**THE APPLICANT'S COMMENTS ON THE SUMMARY OF  
THE ORAL CONTRIBUTIONS AT THE HEARING**

**FOR THE DEVELOPMENT CONSENT ORDER  
APPLICATION FOR THE ALTERATION AND  
CONSTRUCTION OF HAZARDOUS WASTE AND LOW  
LEVEL RADIOACTIVE WASTE FACILITIES AT THE EAST  
NORTHANTS RESOURCE MANAGEMENT FACILITY,  
STAMFORD ROAD, NORTHAMPTONSHIRE**

**PINS document reference: 12.4**

## The Applicant's response to the 'Written summaries of oral contributions at hearings' submitted by Anglian Water at D4 (REP4-014)

Figure ESA5.1 Scale: 1:2,500@A2

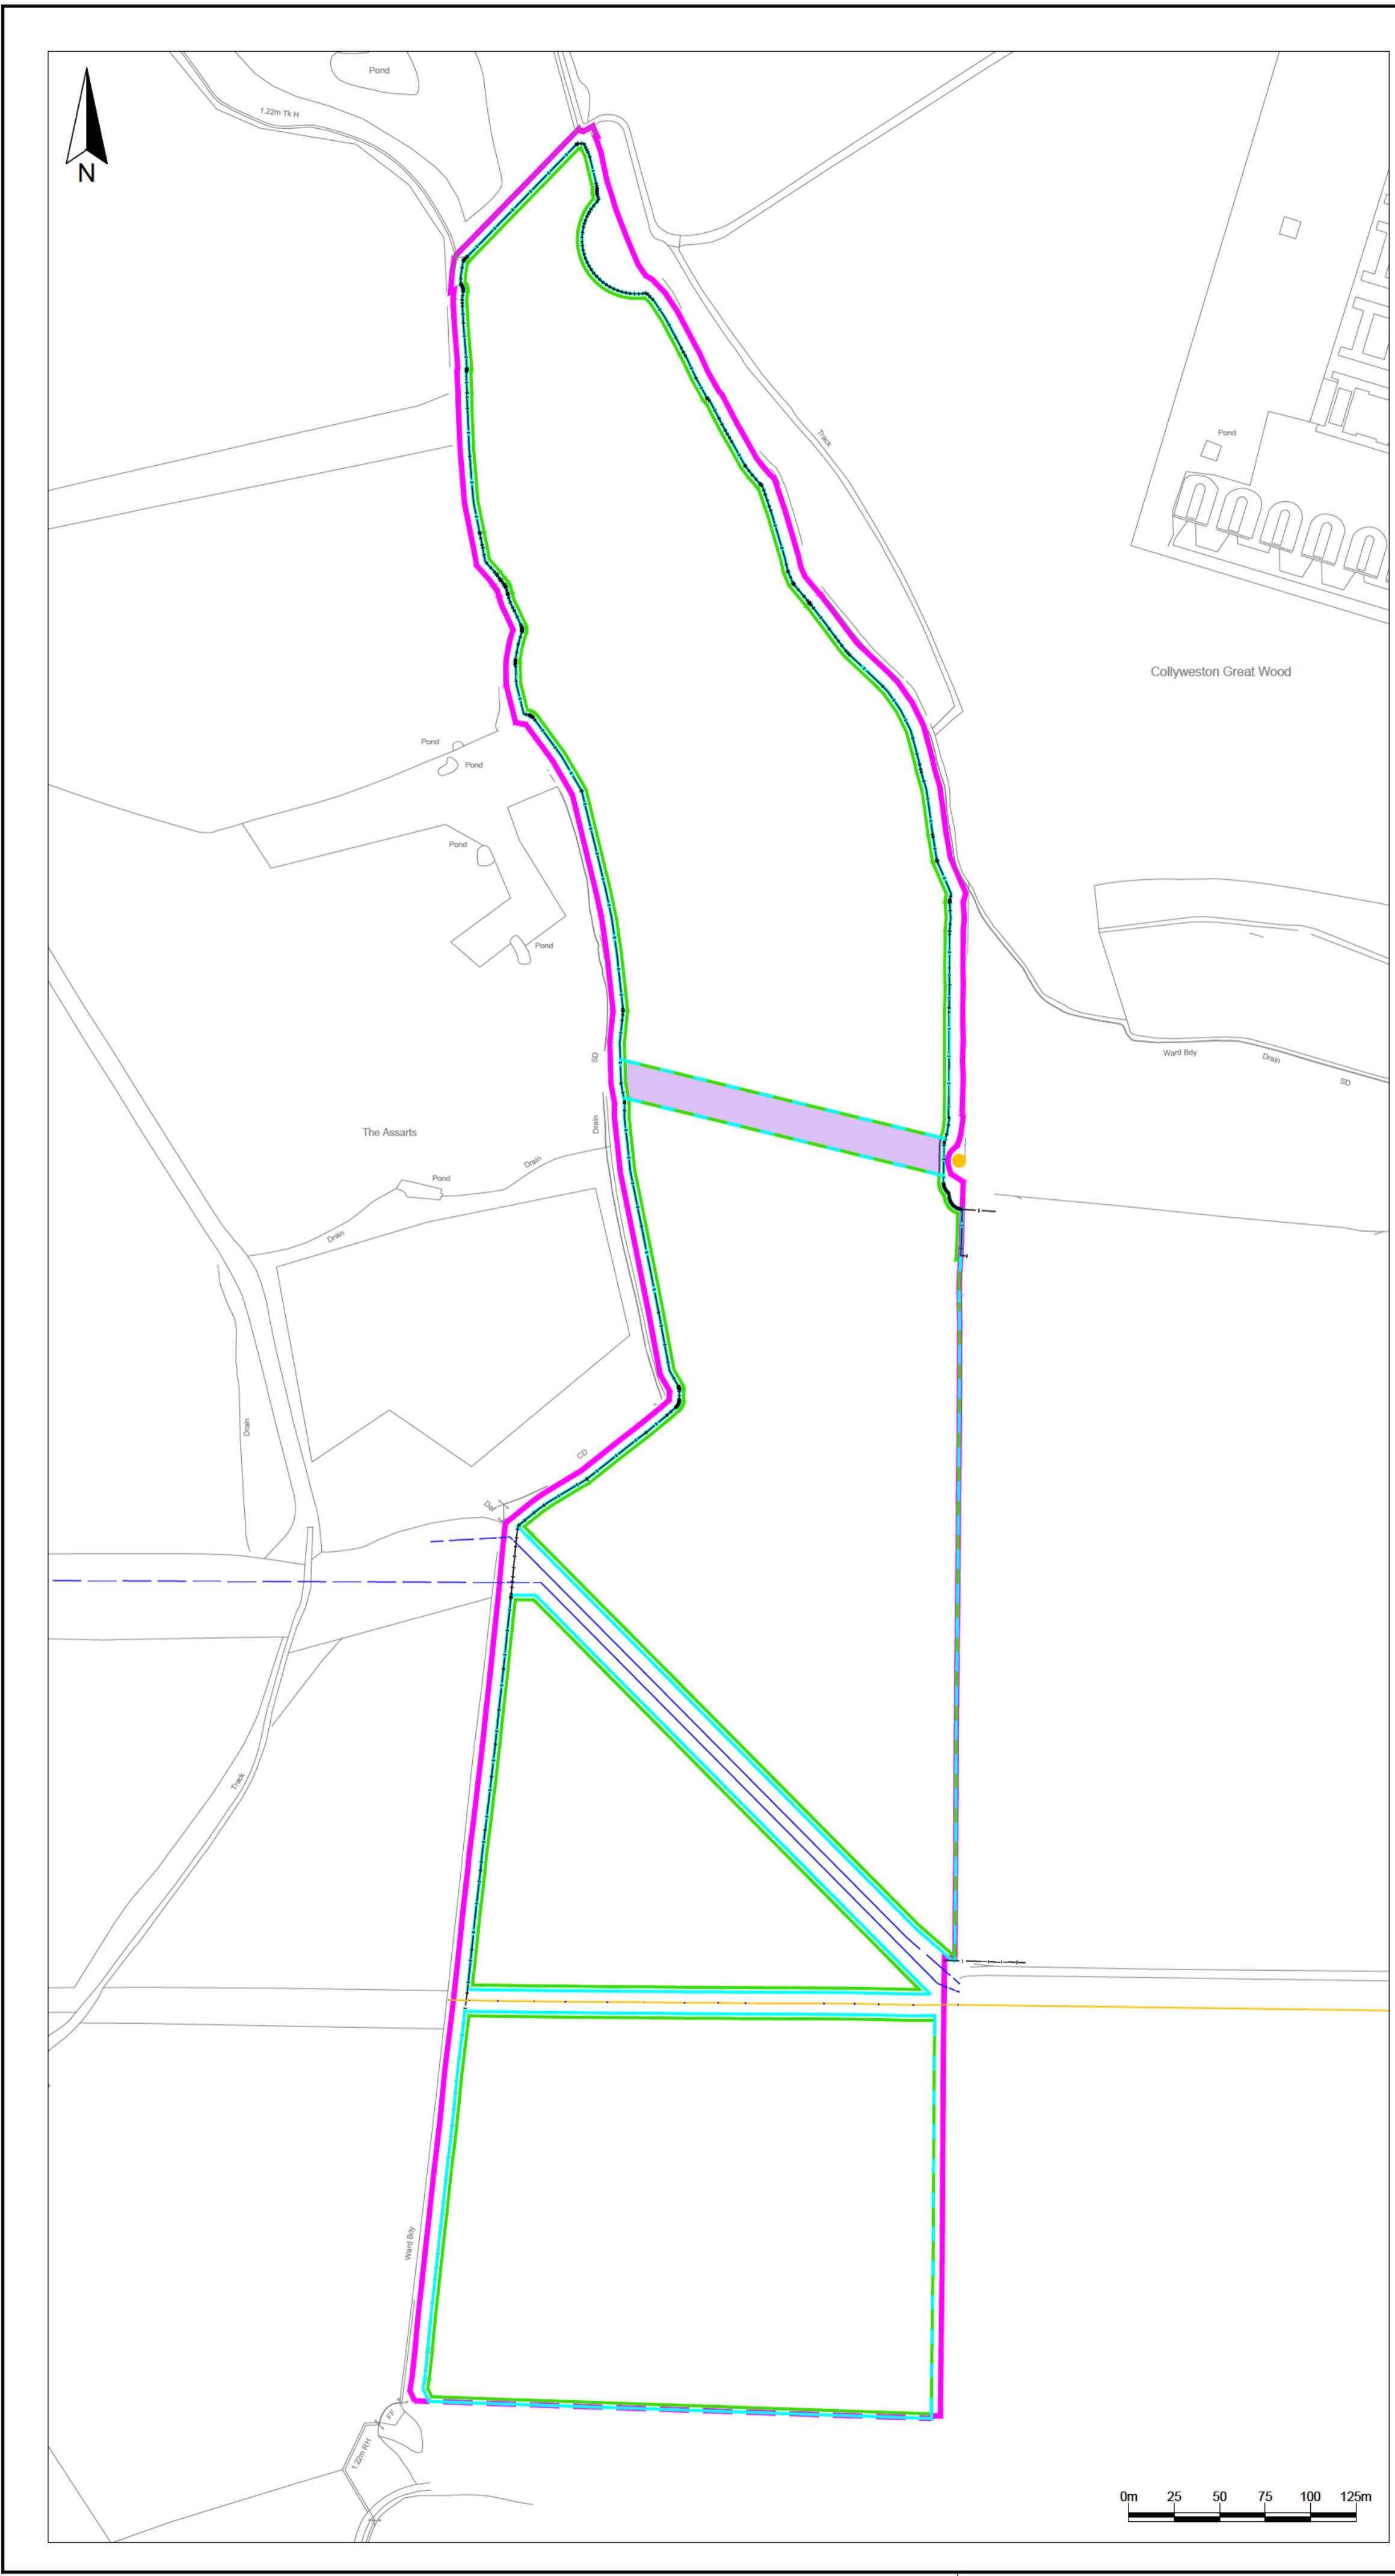
Paragraph number	Comment in the submission from Anglian Water	Response from the Applicant
	<p>our first preference is for the water pipelines to be relocated to land outside of the construction and operational area for the ENRMF. The limited information provided by Augean suggests that standoff distances either side of the two pipelines would need to be in excess of 20 metres to enable safe access. The relocated Western Power electricity transmission cable would need to be outside the 20m plus standoff and therefore next to the landfill cell area. The standoff distance is in part to enable safe work given there are two pipelines, the area is not flat farmland but between two engineered cells and work by Anglian Water or Western Power would require both a plant and machinery, a running area for vehicles and lay down areas for materials and excavations.</p>	<p>The Applicant accepts that there is the potential for Mains to leak and fail catastrophically, as for all water pipes, and that there will be a need for access to be available so that they can be repaired. This is what the standoff distance is intended to allow for and what the Applicant thought had been agreed. The Applicant is working proactively to elucidate as precisely as possible the access needs of AW so that the appropriate standoff distance can be determined.</p> <p>The Applicant has requested information on the distance of standoff to be maintained from landfill operations and any ground structures such as hedges and fences as well as details on any limitations of restoration soil depth and/or gradient placement in the standoff area.</p> <p>It is considered that the provision of laydown areas does not need to be accommodated within the standoff area as an agricultural field with an access track is available at the eastern end of the pipeline area.</p> <p>We draw to the Examining Authority's attention that the pipeline to the south of the existing landfill was installed by AW approximately 15m - 20m to the south of the landfill. In addition, the water pipelines are bounded by a gas main approximately 4m to the south. It is also observed that to the west of the development the pipelines pass through the Assarts and are between 11m and 13m from the trees. From discussion with AW on 9 May 2022 it is understood that a 20m standoff would be acceptable from an operational access perspective and, we are informed by AW, is consistent with the standoff requirement for the current Strategic Pipeline Alliance Pipeline currently being developed in the region. The Applicant is considering the comparative appropriateness of this proposal within the risk assessment process.</p>

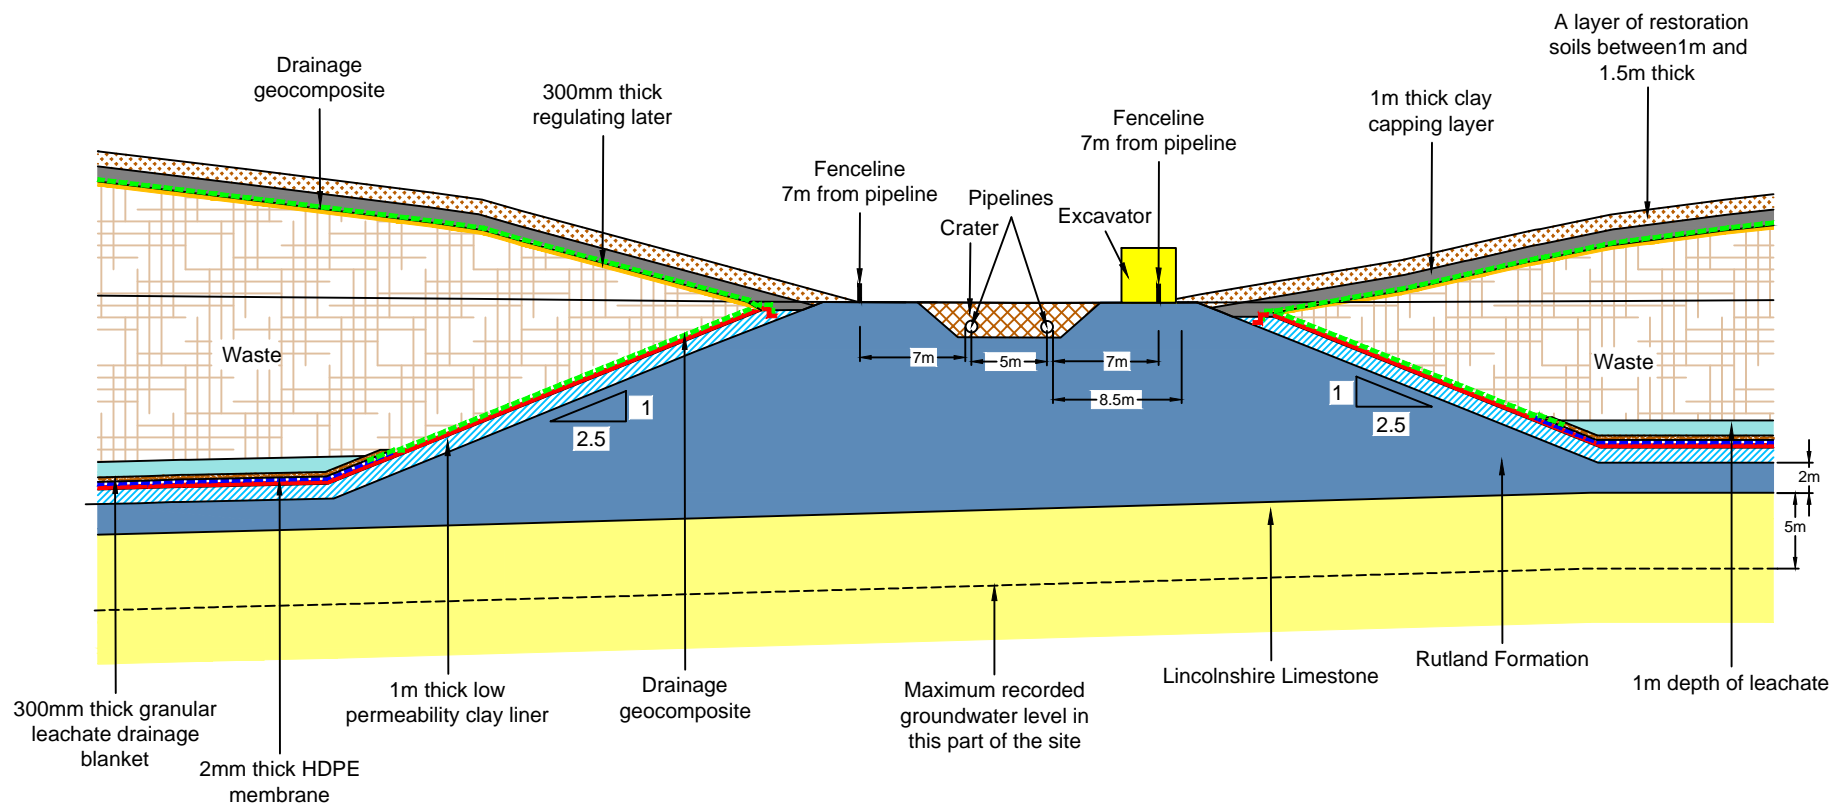
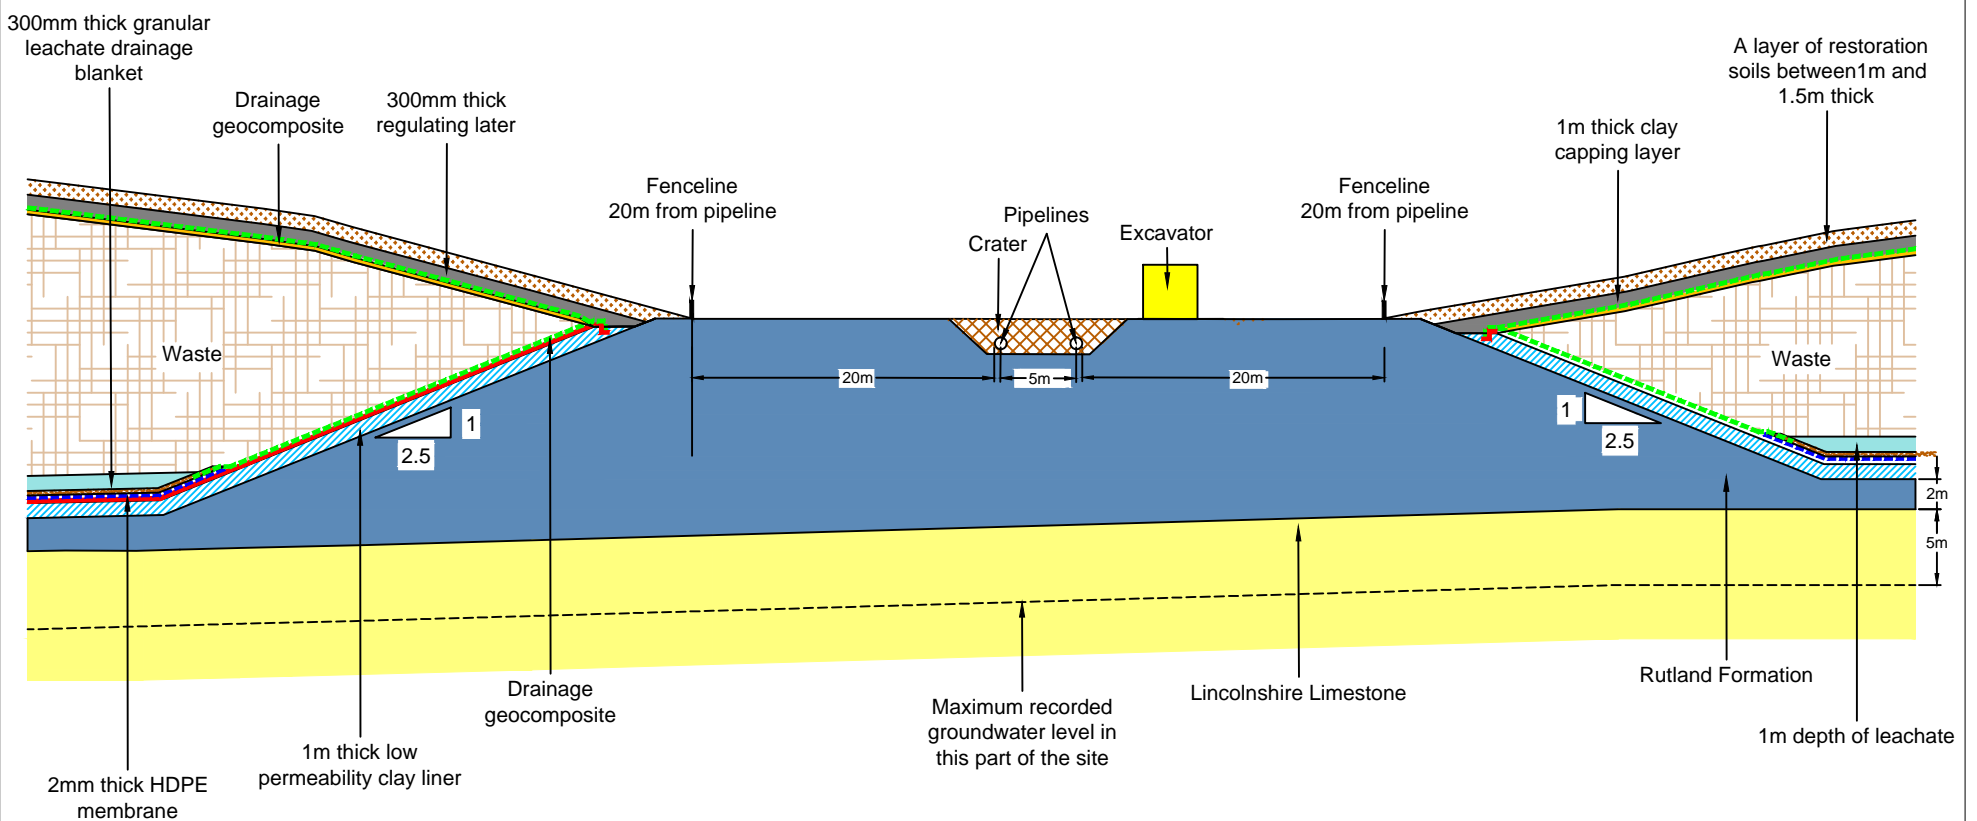
4	<p><b>Contamination</b> As set out by Anglian Water at the 1 March meeting with Augean the risk from contamination is</p>	<p>Now that this concern regarding the effect of a mains burst on the integrity of the landfill containment has been raised, the Applicant proposes to carry out a risk assessment for this eventuality. AW has been requested to provide basic factual information regarding the pipelines and the</p>

Paragraph number	Comment in the submission from Anglian Water	Response from the Applicant
	<p>not solely from leachate. There are other pathways including the risk of a burst pipeline causing both pipes to fail and then the pressure from the pipelines blowing out the cell wall. One further pathway is from water runoff from the engineered restored landfill slopes into the area between the cells through which the pipelines run. This additional flow of water into the area in and around the pipes increases the risk of a burst. It is for Augean to set out in its ESC and SRA within the ES how all the risks have been assessed, designs changed and mitigation measures included. That assessment should include ground investigations near to the two pipelines.</p>	<p>guidance used by AW to enable the Applicant to estimate the size of the crater which could form in the event of a catastrophic failure. In addition, the Applicant is seeking advice from a pipelines specialist on this matter.</p> <p>It is understood that AW may be concerned that surface water run-off from the landfill will result in inundation of the pipe bedding around the pipeline resulting in increased corrosion. However, the pipelines are at a depth of over 1m below ground level beneath and within the natural low permeability clays of the site, in addition surface water run off from the landfill will be directed away from the route of the pipelines. As the ground above the pipes will no longer be farmland it is more likely that there will be less water infiltrating the soils and possibly reaching the pipe bedding rather than more as the field will no longer be ploughed and the ground will no longer be broken up. Nevertheless, it is understood that it is possible to monitor the level of water around the pipeline and the Applicant is prepared to offer to monitor the water levels around the bedding in the 10 years prior to landfilling near to the pipeline and following landfilling so that if additional drainage measures are identified as necessary, they can be implemented.</p> <p>The concerns which now have been raised will be properly addressed by risk assessment based on which final design decisions can then be made.</p>
